Planning Officer: Tracey Headley-Smith
Planning Application Ref: M/95/18/T
Location: 7 Hadley Close, Middleton-On-Sea, PO22 6PG
Description of works: Reduce height of 3No. Hazel trees by 8m
Reasons Given: None given

Tree Officer / Parks and Greenspace Team

7 HALLWAY CLOSE

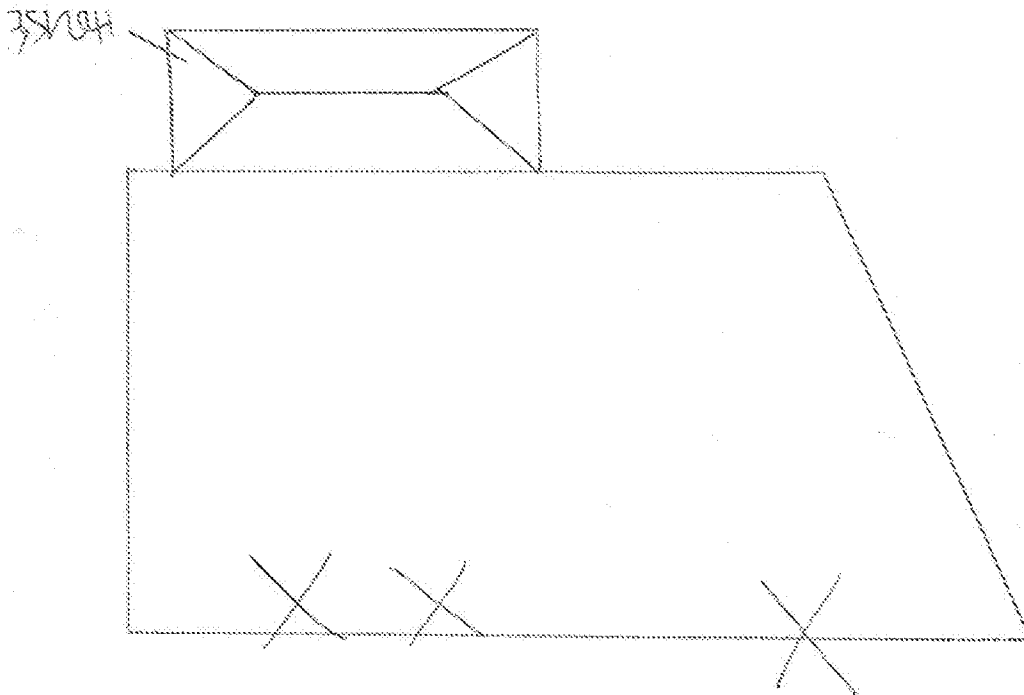
- These three trees are actually established coppice stools giving rise to multiple stems.
- The applicant seeks a height reduction of such extent that it is in effect a re-coppicing operation.
- They provide some visual amenity to surrounding properties but offer little if any to the wider public.

- Coppicing on a rotation of 10-25years is an established management technique for this tree type and should be repeated on a regular basis once initiated.
- If the work is undertaken to a good standard and at the right time; then it is unlikely to have an adverse effect on the trees long-term vitality.

- I recommend **CONSENT** is given for this application.
